SHOALHAVEN CITY COUNCIL

**SUBMISSION TO THE NSW DEPARTMENT OF PLANNING, INDUSTRY AND
ENVIRONMENT**

**COUNCIL'S SUBMISSION TO AMENDED PLANS
EXHIBITED BY THE NSW LAND & ENVIRONMENT COURT
(CASE NUMBER 2019/00078149)**

MAJOR PROJECT APPLICATION CONCEPT PLAN SSD3846

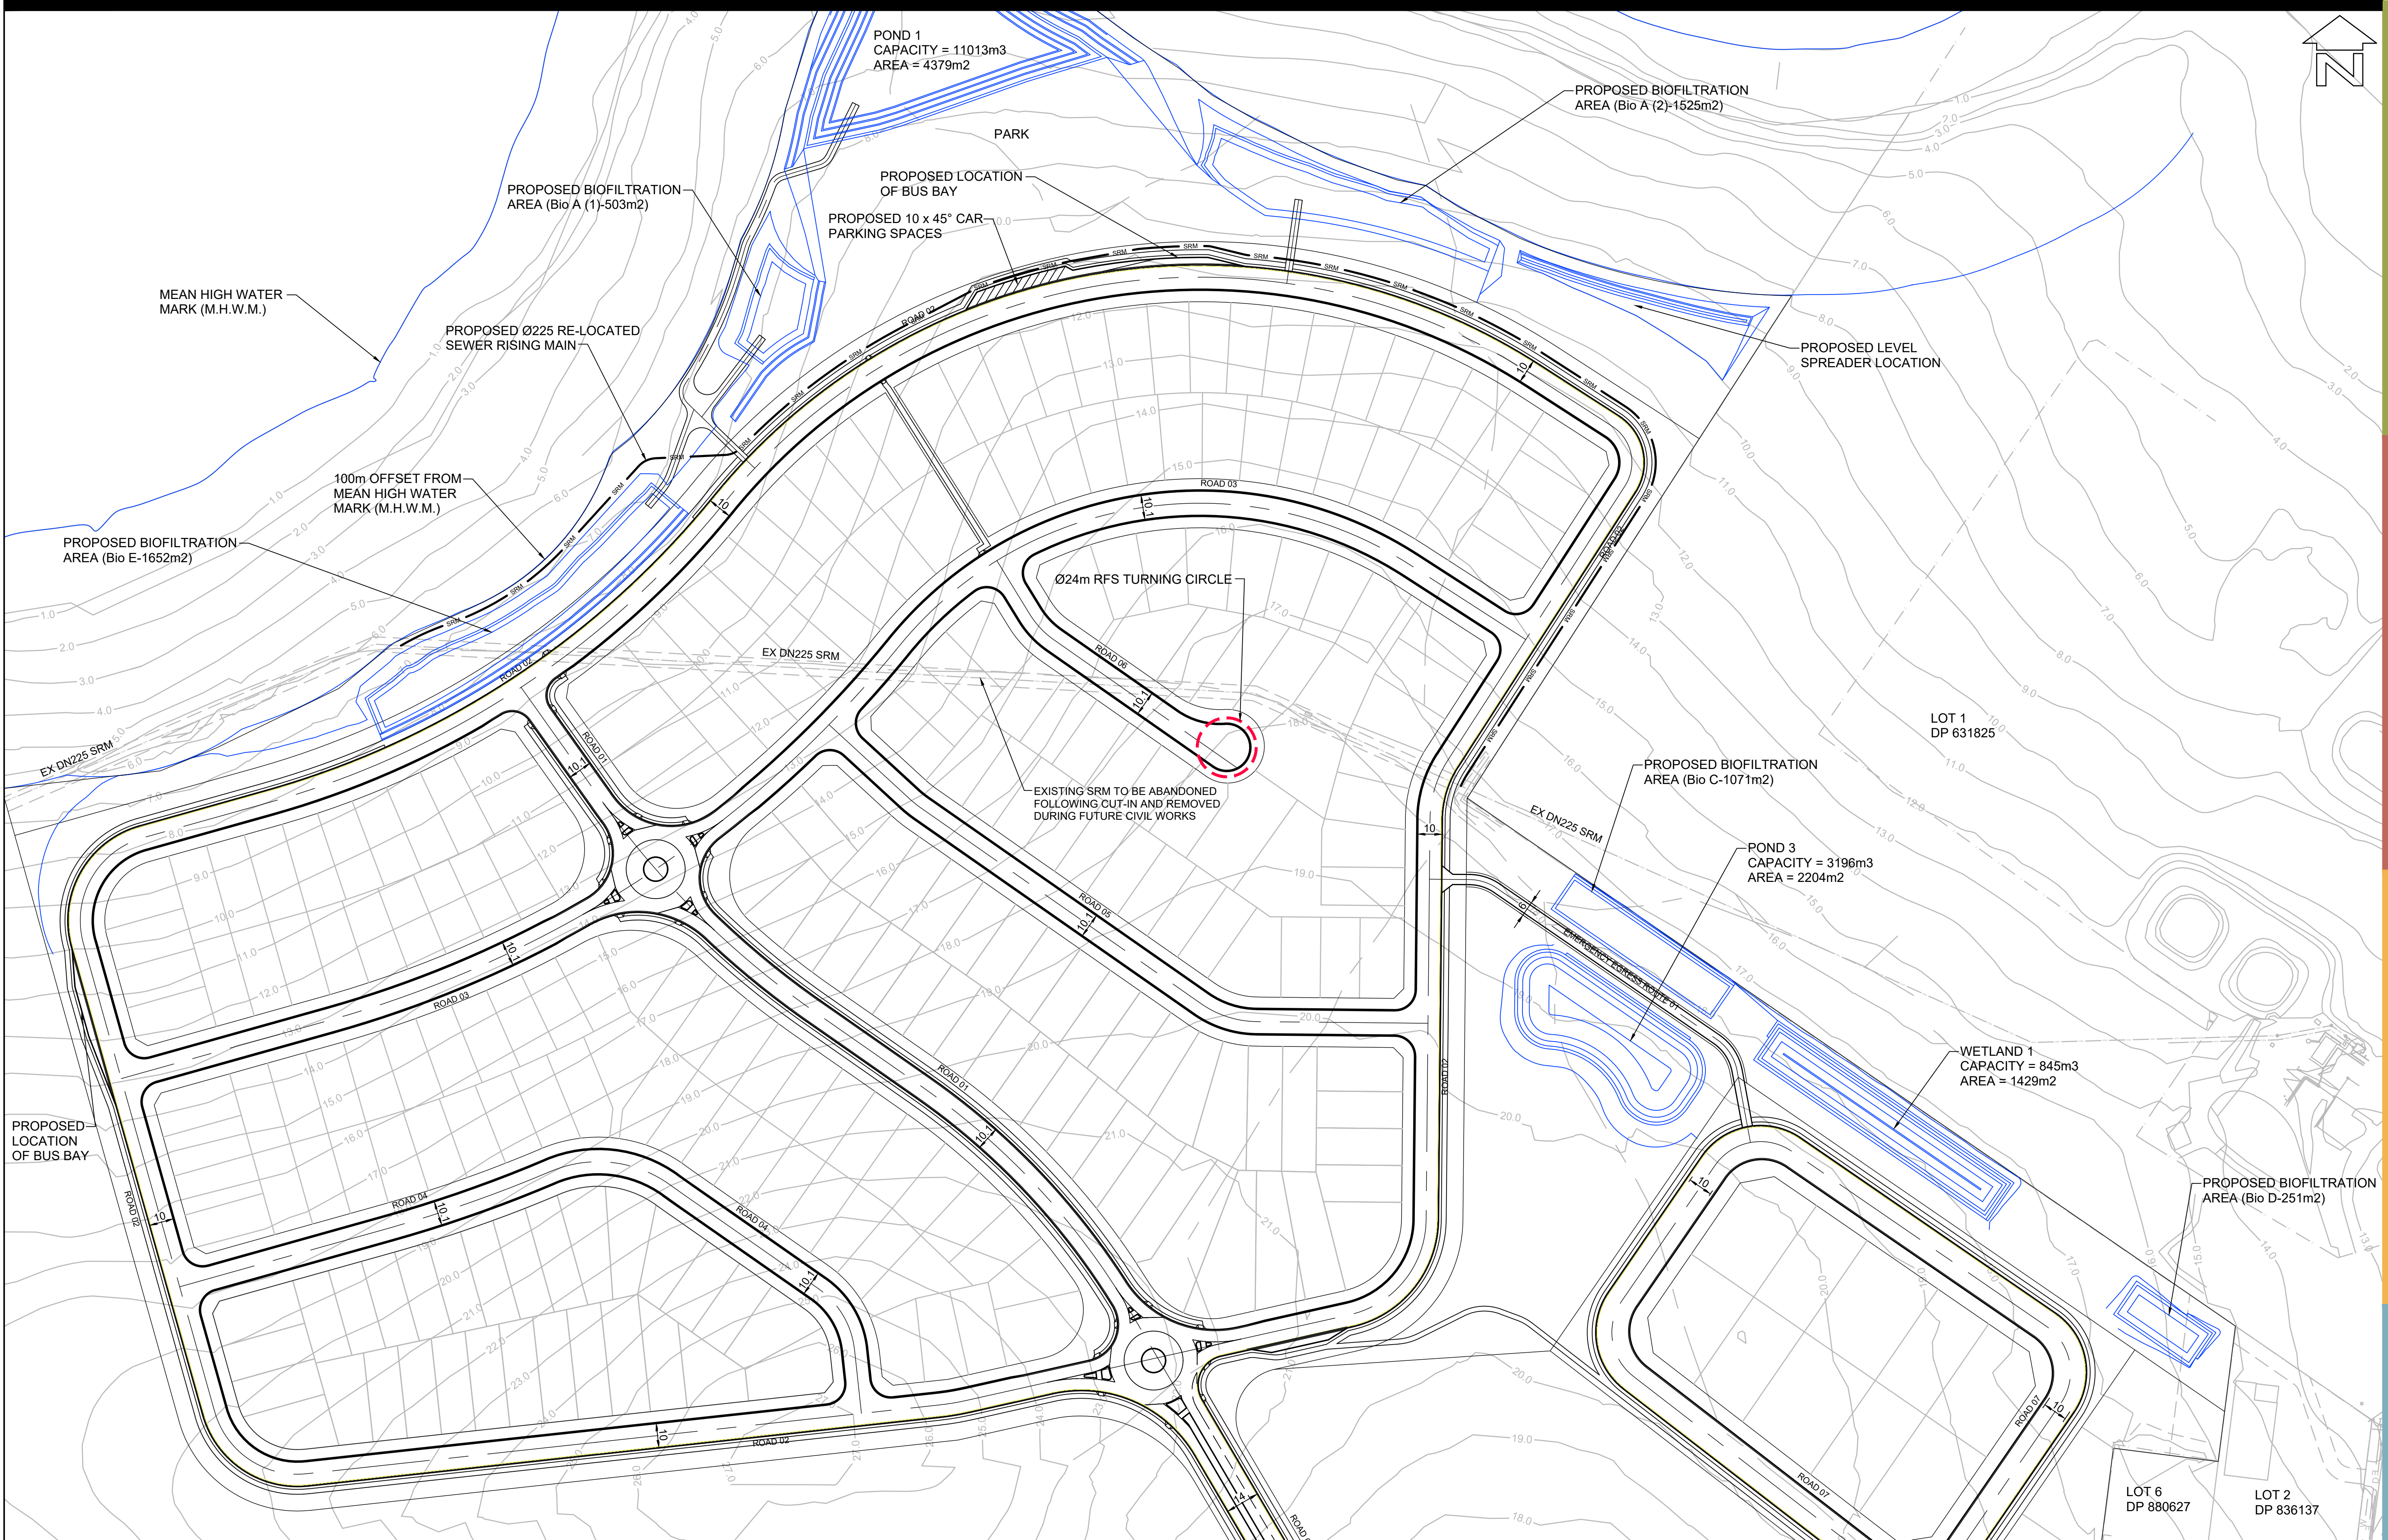
There is concern with the laneway proposed on the latest set of plans for the integrated housing lots. Council's DCP only allows this type of arrangement for a limited number of lots and given that the applicant has proposed 45 rear loaded lots as well as a mixed use

lot to access from this laneway, this is unsatisfactory. The laneway is to be shortened in length to increase the passive surveillance and minimise the visual impact of the laneway. Conditions will be provided to ensure this is resolved with the amended concept plans.

The Preliminary Engineering Plans must be amended to address the laneway within the Integrated Housing Lots area. The laneway must be shortened with additional intersections to the adjacent public roads to increase passive surveillance and minimise the visual impact of the laneway.
